# Middleton-cum-Fordley Parish Council

## Issue Specific Hearing 3: Traffic and Transport

### Post-hearing submission – Additional comments

23rd July 2021

DRAWING TITLE:
 YOXFORD ROUNDABOUT PROPOSED GENERAL ARRANGEMENT

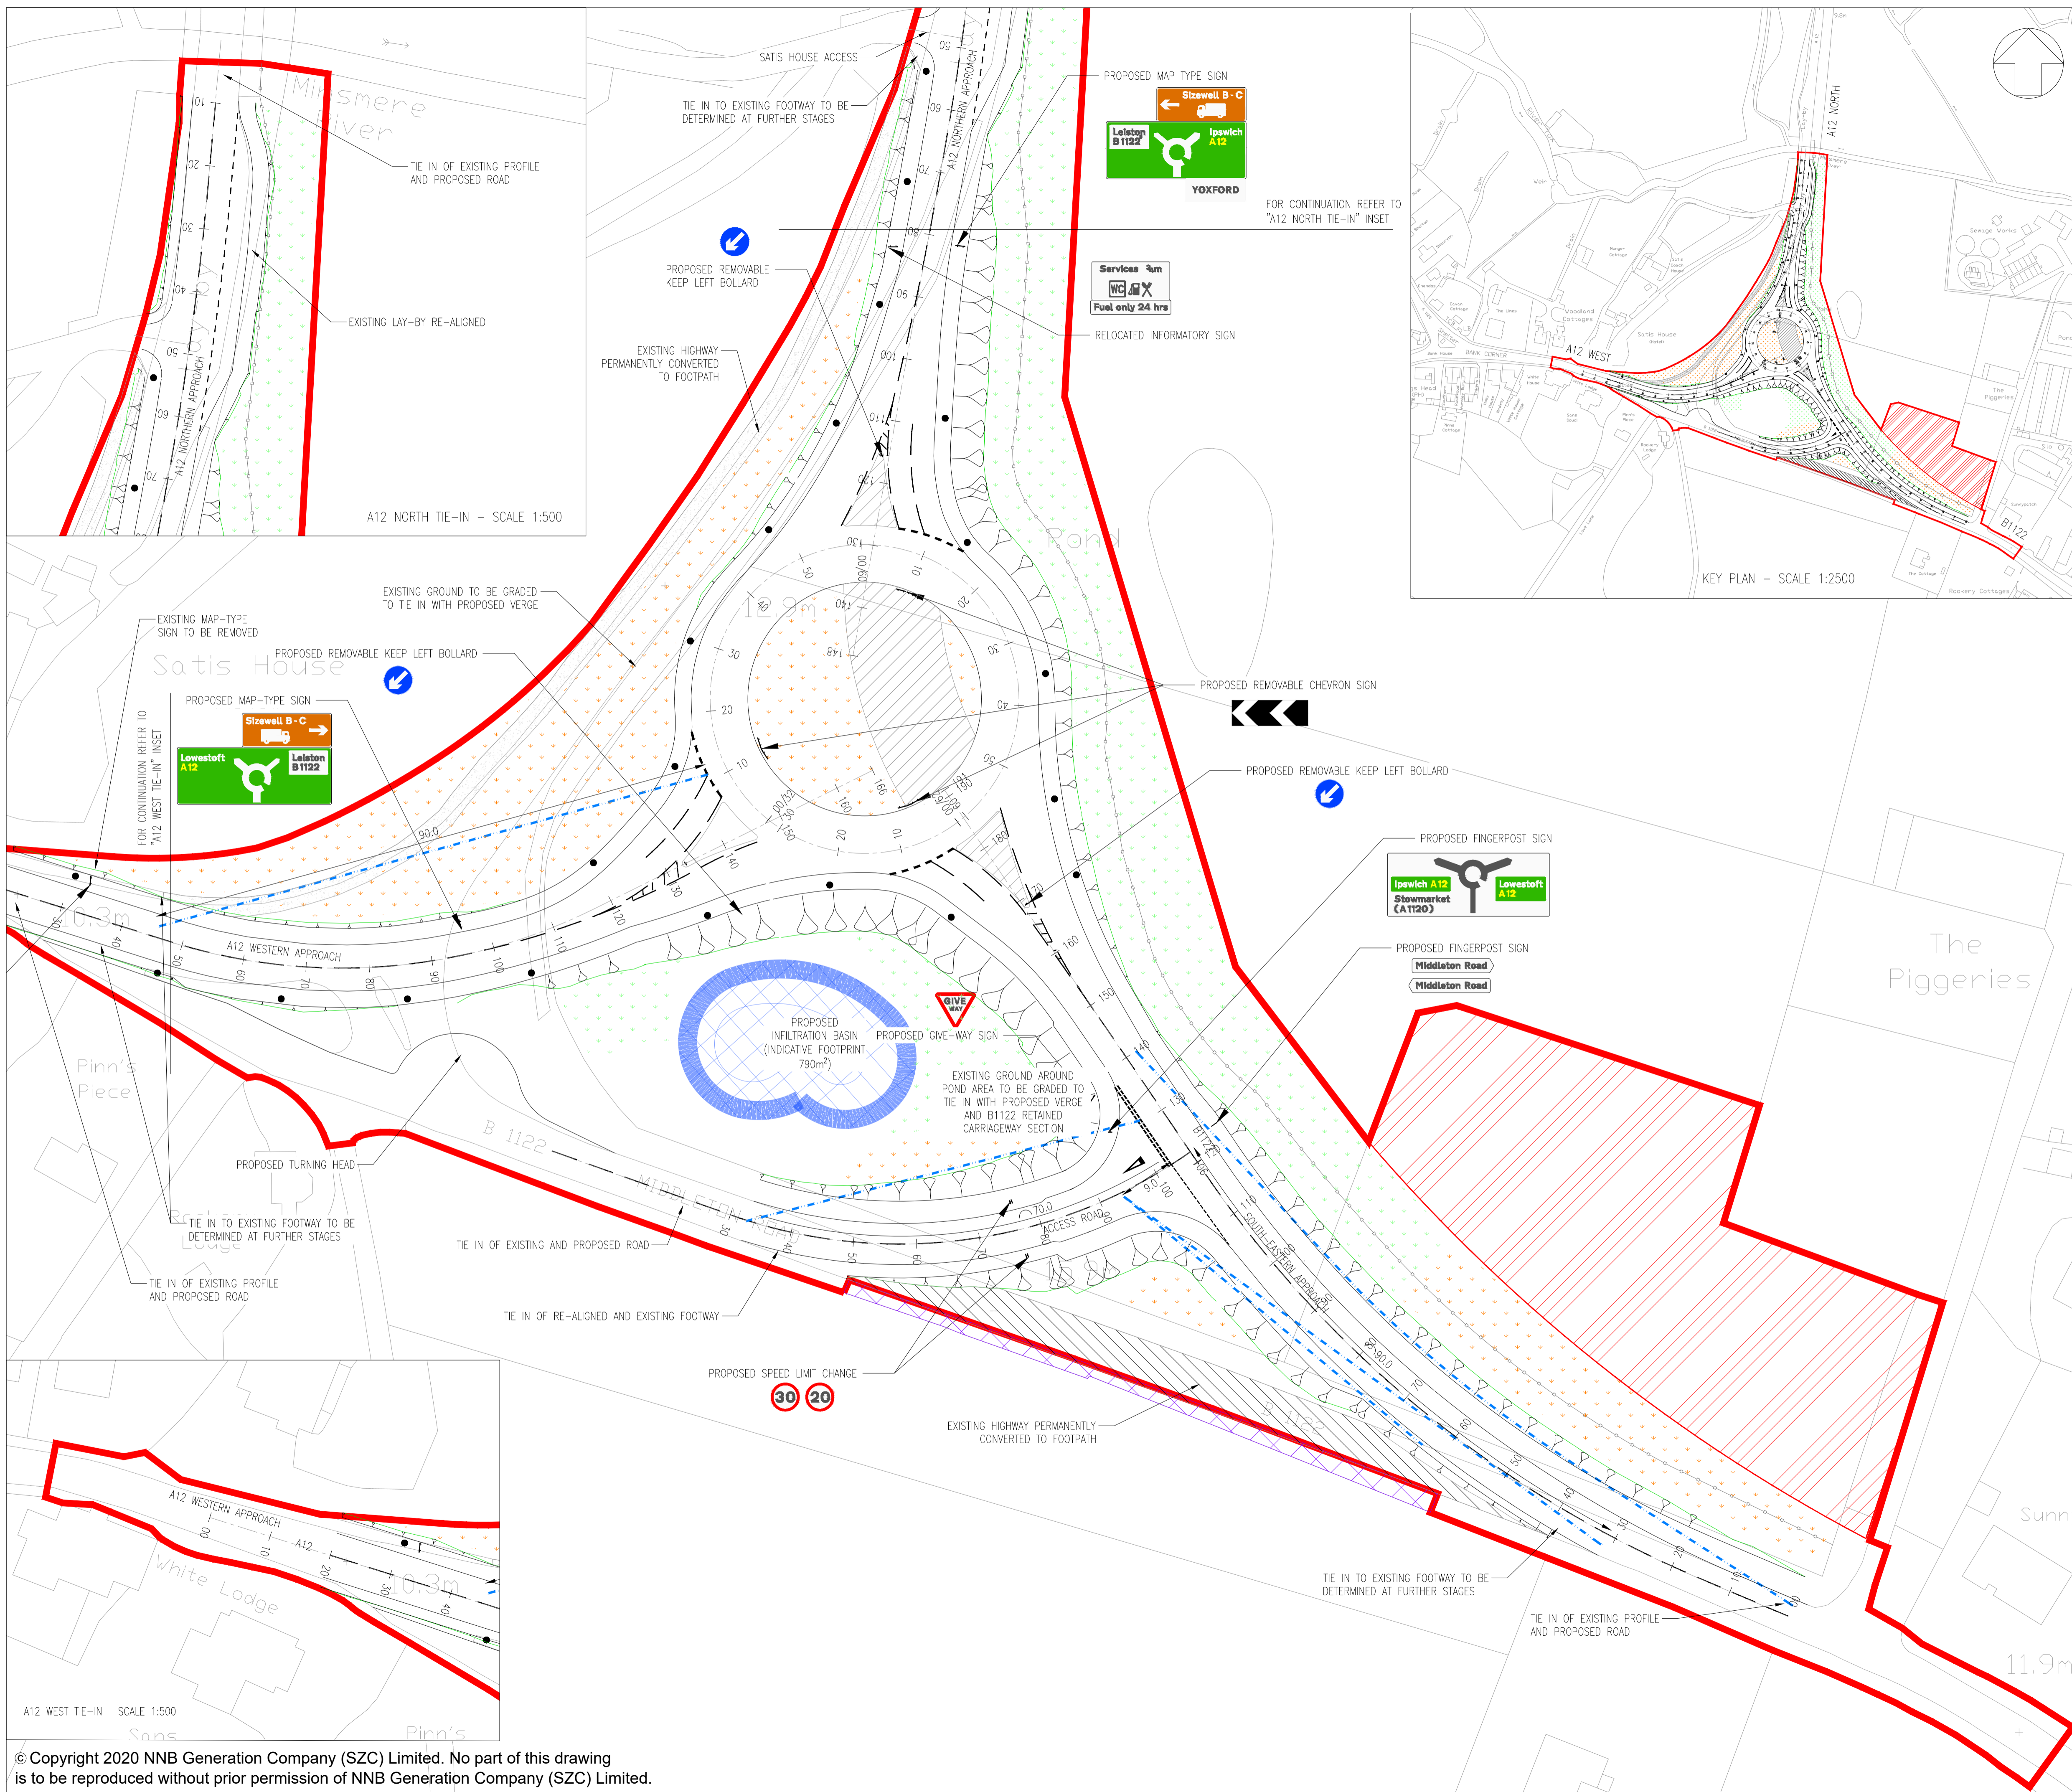
- The lack of any detail about drainage to cater for the Yoxford Roundabout, which will largely be located in a 2 metre deep pit. A big worry, since this area floods all too easily even at present levels. The book of plans that EDF provided for the 2 days of site accompanied visits contained well detailed visions of the proposed works on the existing landscape elsewhere, but unbelievably omitted any showing the Yoxford roundabout. This had not been previously realised by Tom McGarry or Richard Bull of EDF, who undertook to provide same forthwith. To date they have still not been received. Worryingly, the Inspectorate team did not seem phased by this.
